**DELEGATED DECISION TO DETERMINE PLANNING APPLICATIONS**

**Reference No:** 2021/62/90253/W

**Site Address:** 43 , Gramfield Road, Crosland Moor, Huddersfield,  
HD4 5QB

**Description:** Erection of single and two storey rear extension and  
side porch

First Floor Layout 1.50

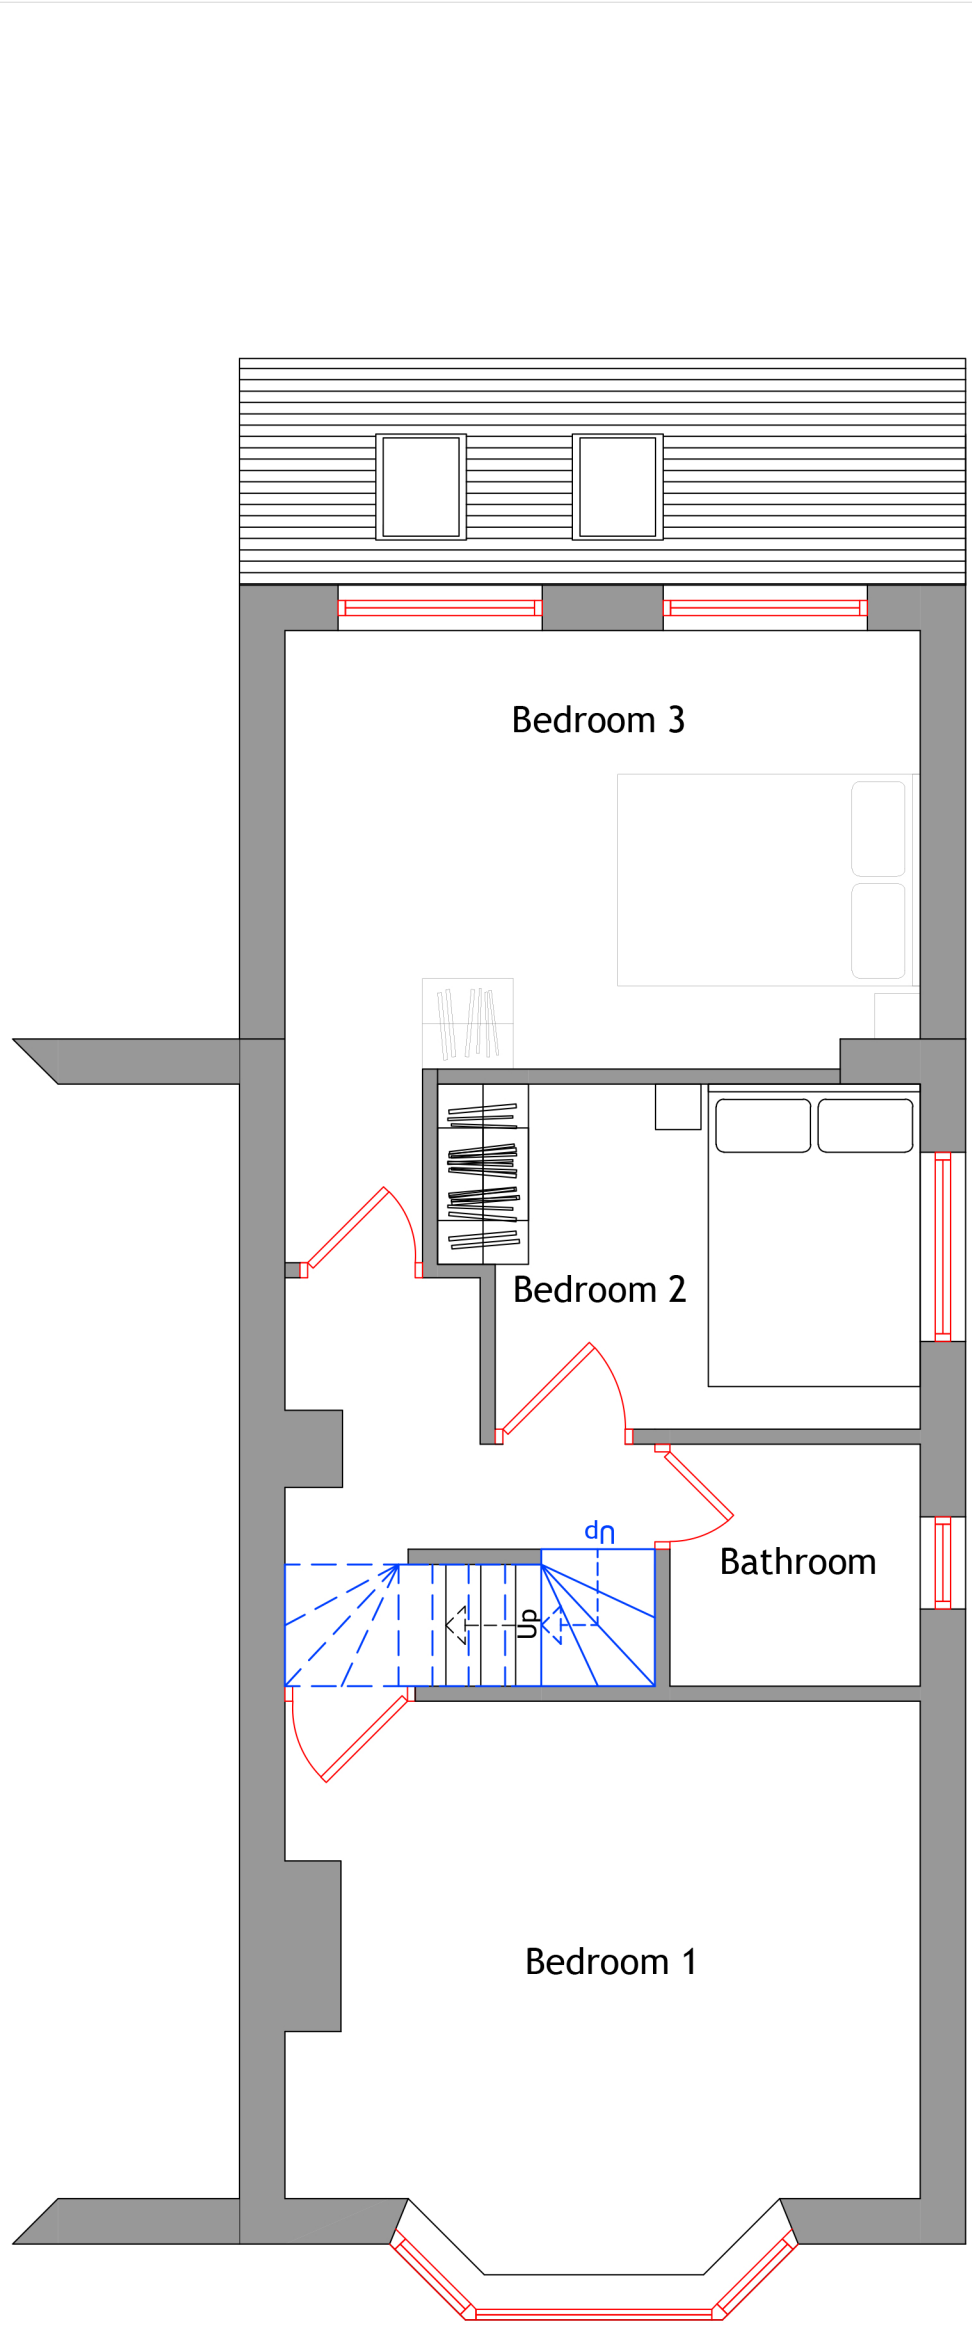
Officers have entered into various discussions with the agent regarding the projections of the single and two storey rear extensions and the impact in which they propose to visual and residential amenity. As such, a compromise has been reached to reduce the first floor to 3m and the ground floor to 4.5m.

Whilst it is appreciated that the majority of the works would extend beyond the rear elevation, it would not result in the overdevelopment of the site. Significant amendments have also been sought to reduce the footprint at ground floor from 6m to 4.5m. The single storey side extension would also

However, in this case, any overbearing is not considered to be detrimental, given the amendments sought to reduce the first floor projection to 3m. The ground floor extension will also be retained at a length no greater than 4.5m. As such, any impact on balance would not be detrimental. In terms of overshadowing, the proposal would lead to additional overshadowing from afternoon to evening, however the impact is on balance considered to be acceptable given the 3 metre first floor protection, the use of a hipped roof at first floor and lean to roof aiding in reducing the bulk of the extension.

| <b>Plan Type</b>                                                 | <b>Reference</b> | <b>Version</b> | <b>Date Received</b>          |
|------------------------------------------------------------------|------------------|----------------|-------------------------------|
| Proposed site plan, floor plans and elevations                   | 1539/02A         | -              | 2 <sup>nd</sup> April 2021    |

Given that the proposal has the potential to intensify the domestic use at the site taking the property to a 3 bed, officers have requested that a second on site parking space is provided to the front of the dwelling. In this case, an amended plan has been sought to show this, with the new space being at least 2.4m in width by 4.8m in depth. As such, the additional on site parking is welcomed.

Final amended plans were received on 2<sup>nd</sup> April 2021 to also include a second on site parking space.
